Recommendation Report for Planning Permission for Works or Extension to a Dwelling

REF NO: AW/277/21/HH

LOCATION: 16 Wilman Gardens
Aldwick
PO21 4BP

PROPOSAL: Loft conversion to form new 1st floor with dormers

Proposed

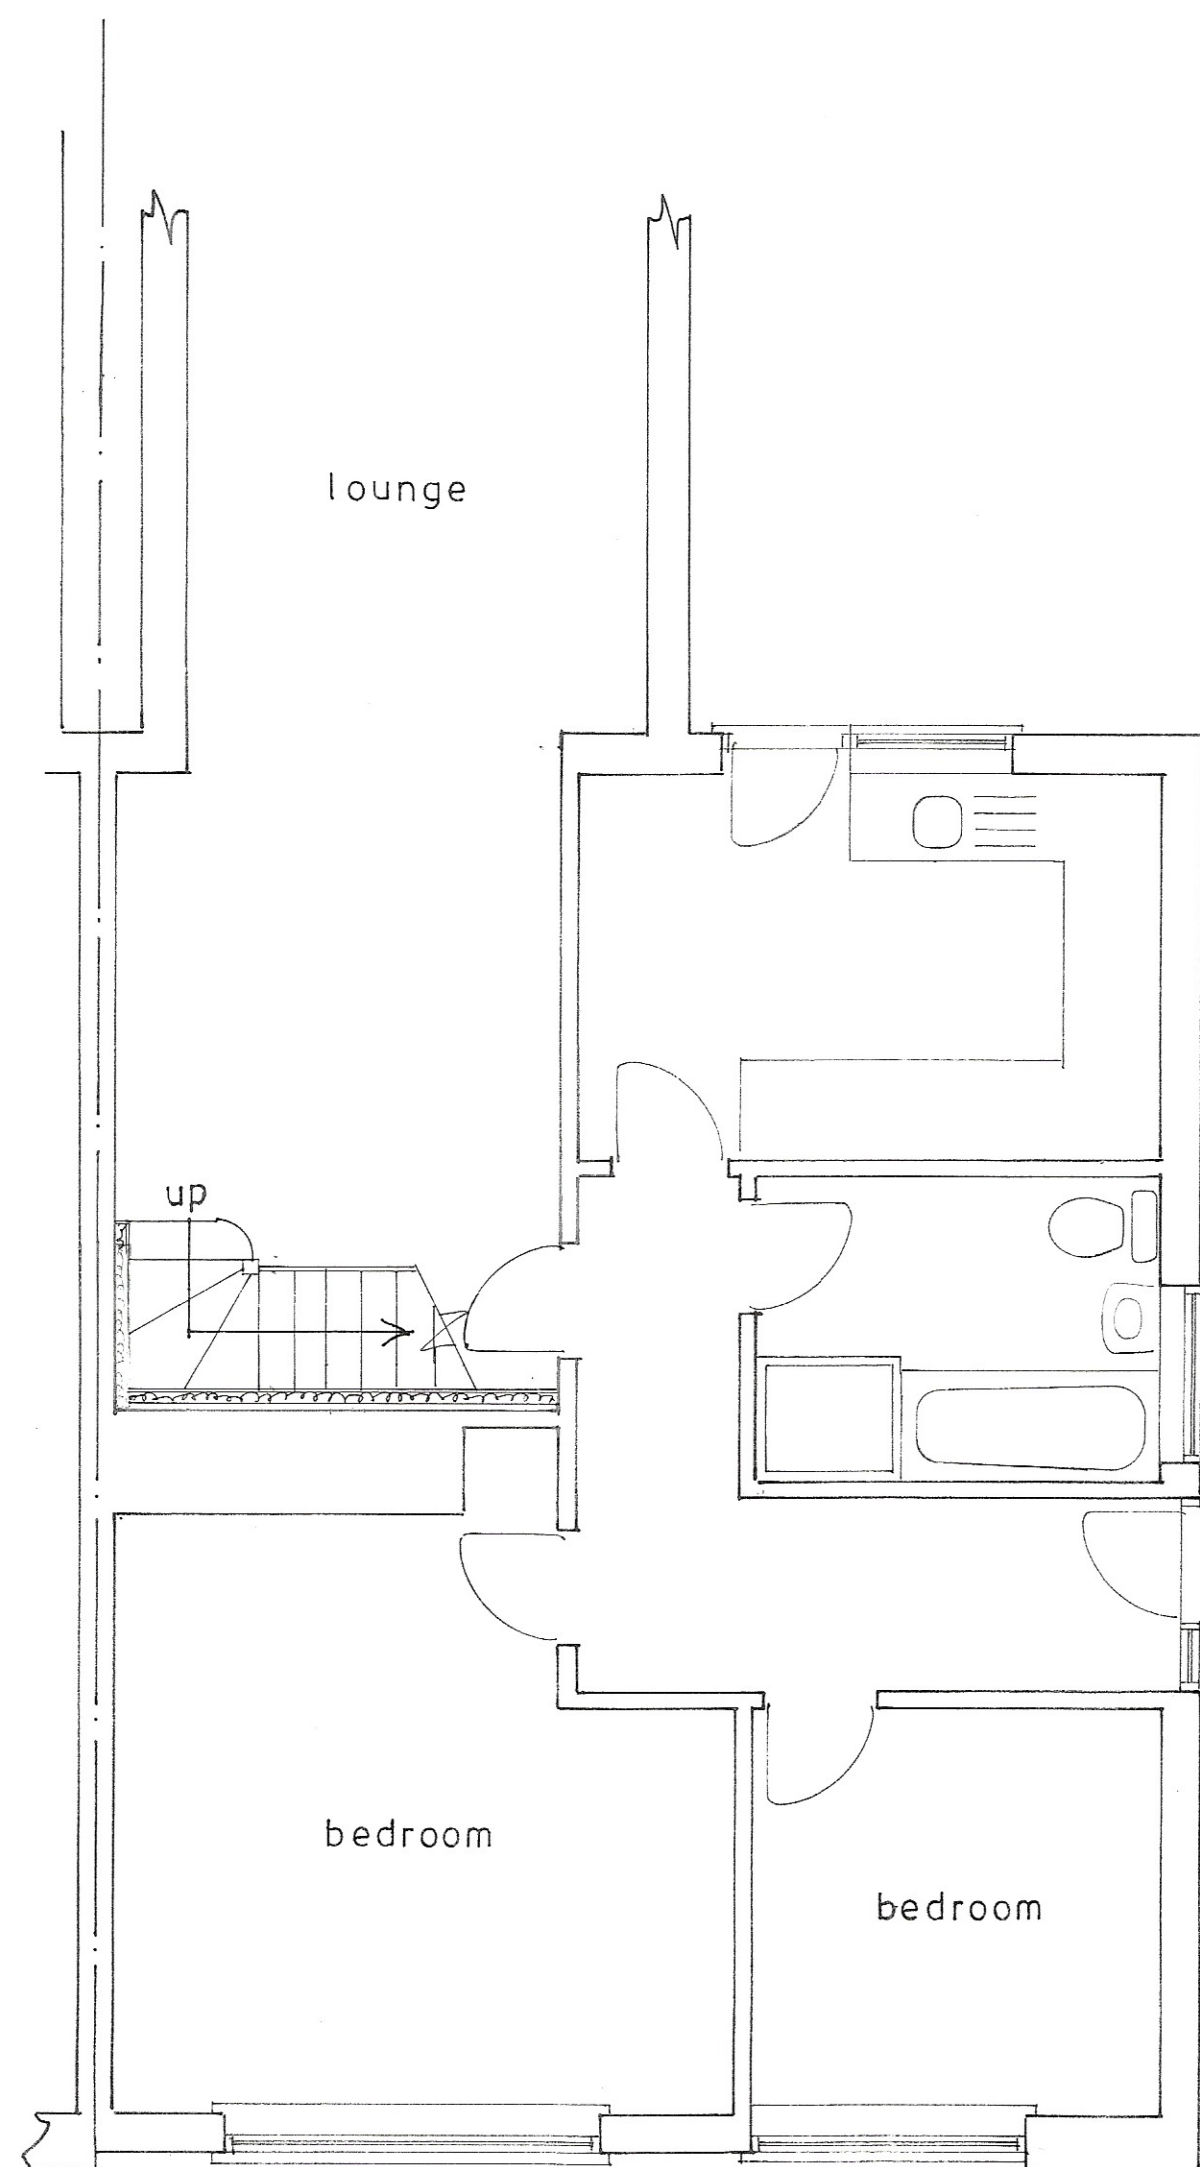
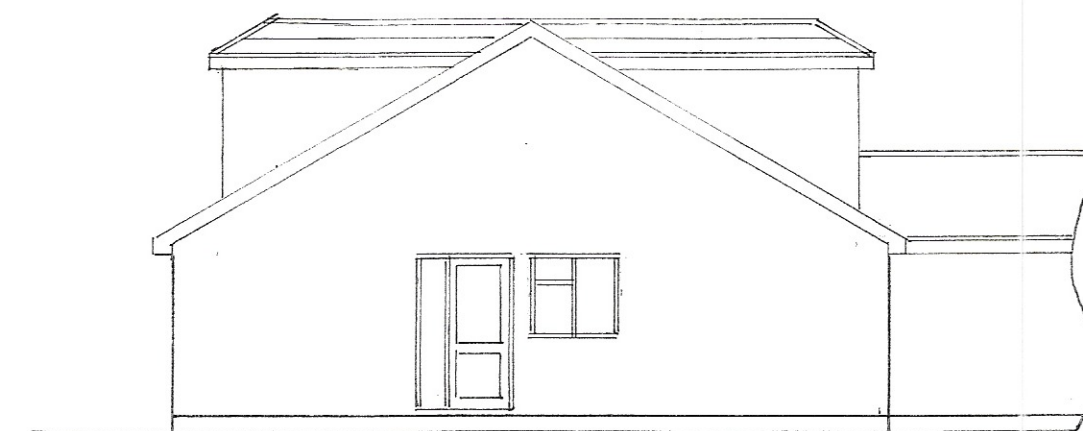
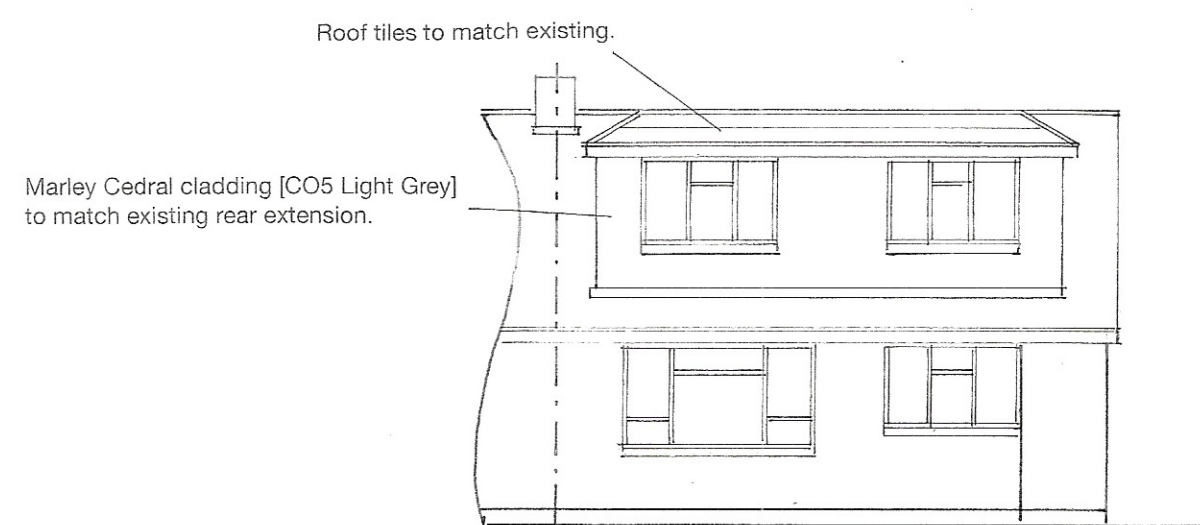
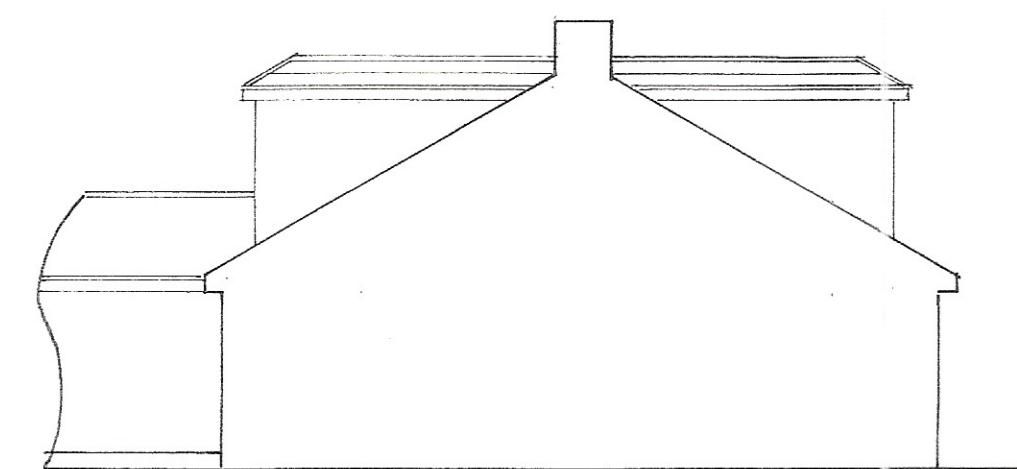
Due to the siting of the dormer to the front it will be highly visible, featuring a flat hipped roof. It is of a large scale which runs the full roof slope, meeting with the ridge height and as a result does not appear visually integrated and is an unduly dominant feature, out of keeping with the character of the area. As such, it is in conflict with D DM4 (a) (b) and (e) of the Arun Local Plan.

Due to scale and size of the front dormer, it is considered to cause adverse harm to appearance of street scene and character of surrounding area and therefore does not comply with Policy D DM1 (1) and D DM4 (a) (b) and (e) of the Arun Local Plan and the Arun Design Guide.

- 1 The front facing dormer by reason of its size and position is an unduly dominant feature and is out of keeping with the appearance of the property and character of the surrounding area, resulting in adverse harm in conflict with policy D DM1 and D DM4 of the Arun Local Plan and Section M of the Arun Design Guide.

1st floor plan
1 : 50

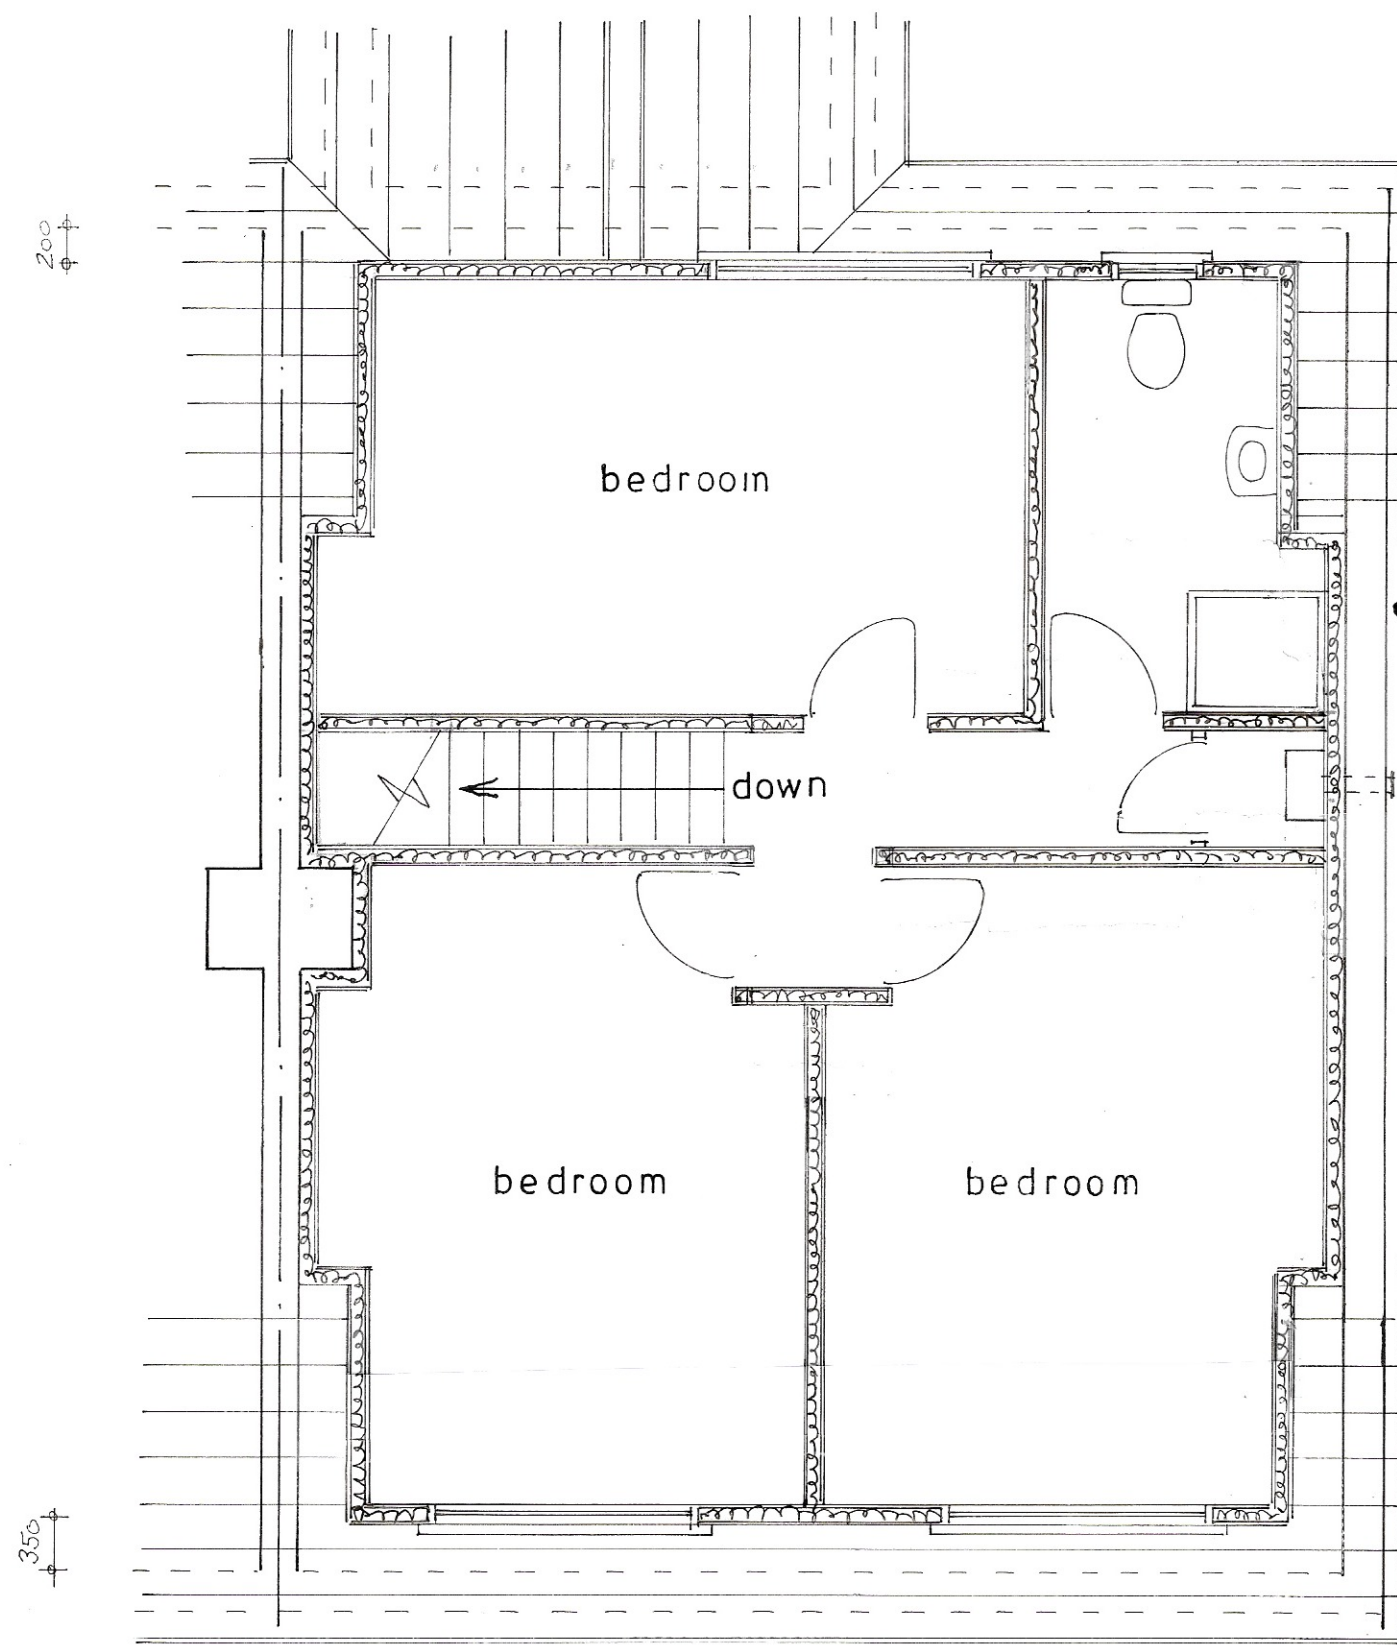
The proposed dormers will have a height of 2.45m, depth of 4m and length of 6.15m.

The rear facing dormer will have 2 windows serving a bathroom and a bedroom. Whilst these will introduce views that are not currently available, with 13m retained to the rear boundary, it is not considered views will be significant. A dormer could also be constructed to the rear under permitted development which would also introduce views similar to that proposed.

The front facing dormer would have views over the street scene and not result in adverse harm.
